STATE OF NORTH CAROLINA
DEPARTMENT OF TRANSPORTATION

Addendum No. 1

RE: Contract ID C203453

Granville County (I-5205B)

STATE OF NORTH CAROLINA DEPARTMENT OF TRANSPORTATION RALEIGH			
STRUCTURE TOTAL BILL OF MATERIAL			
REVISIONS			
NO.	BY:	DATE:	SHEET NO.
1			S-1
2			TOTAL SHEETS
			41

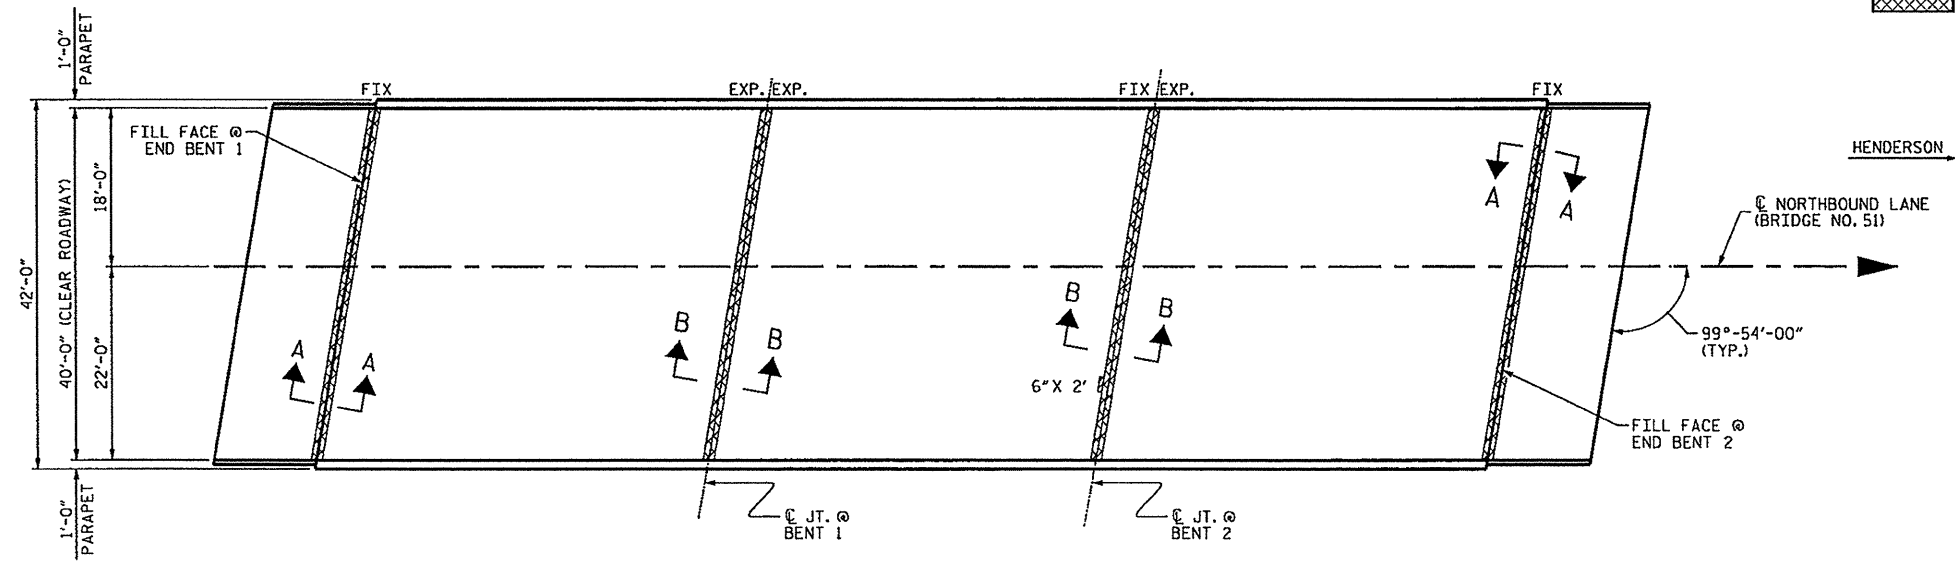
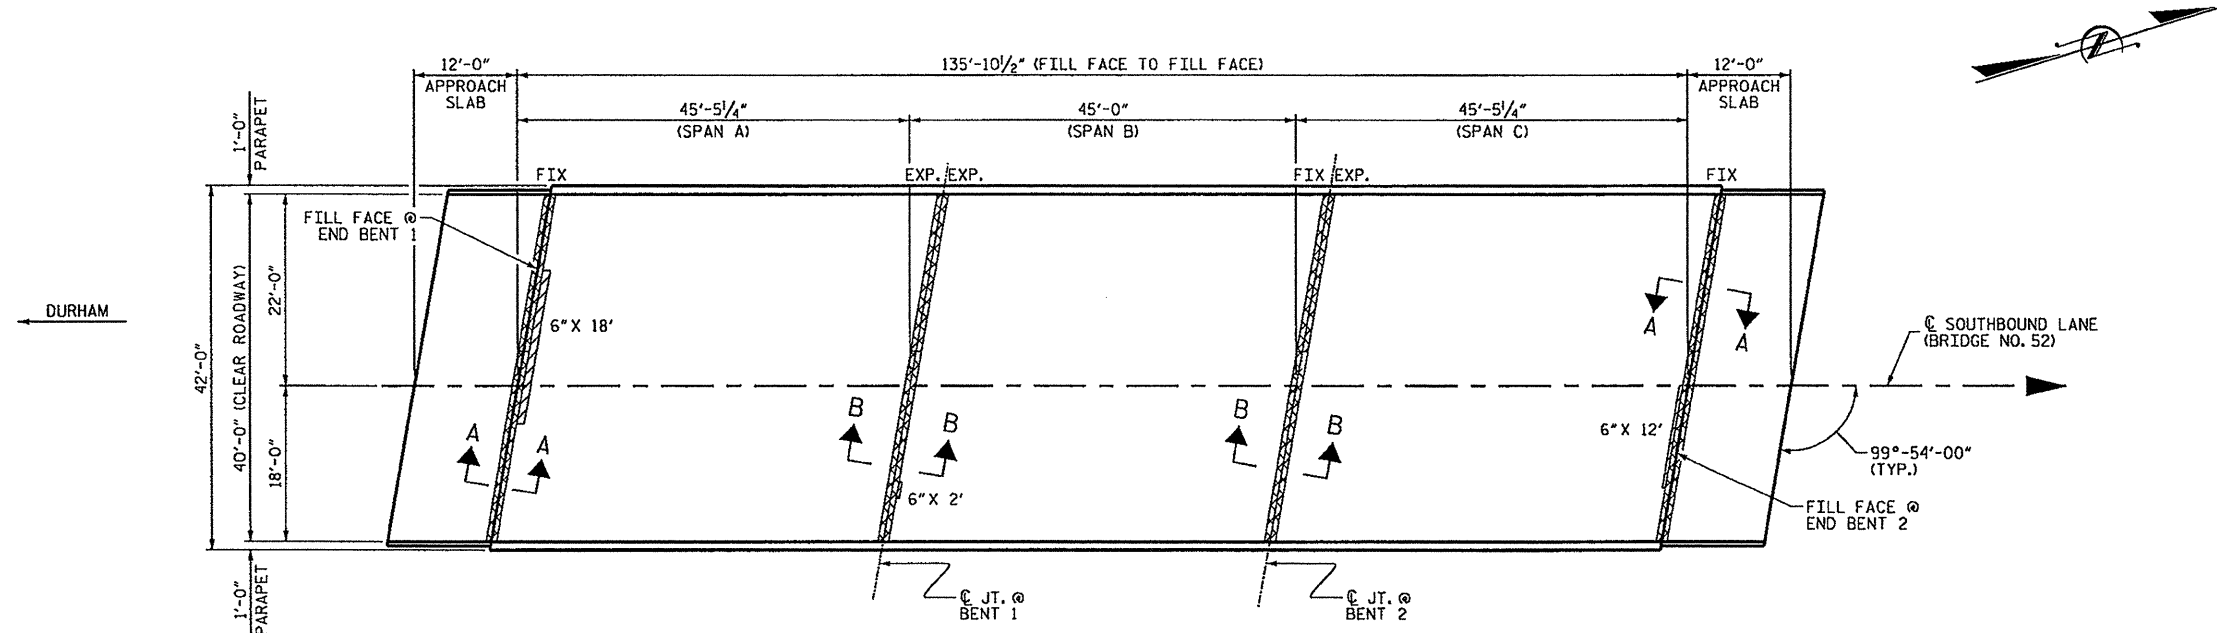
The first note on Sheet No. S-1 has been revised. Please void Sheet No. S-1 in your plans and staple the revised Sheet No. S-1 thereto.
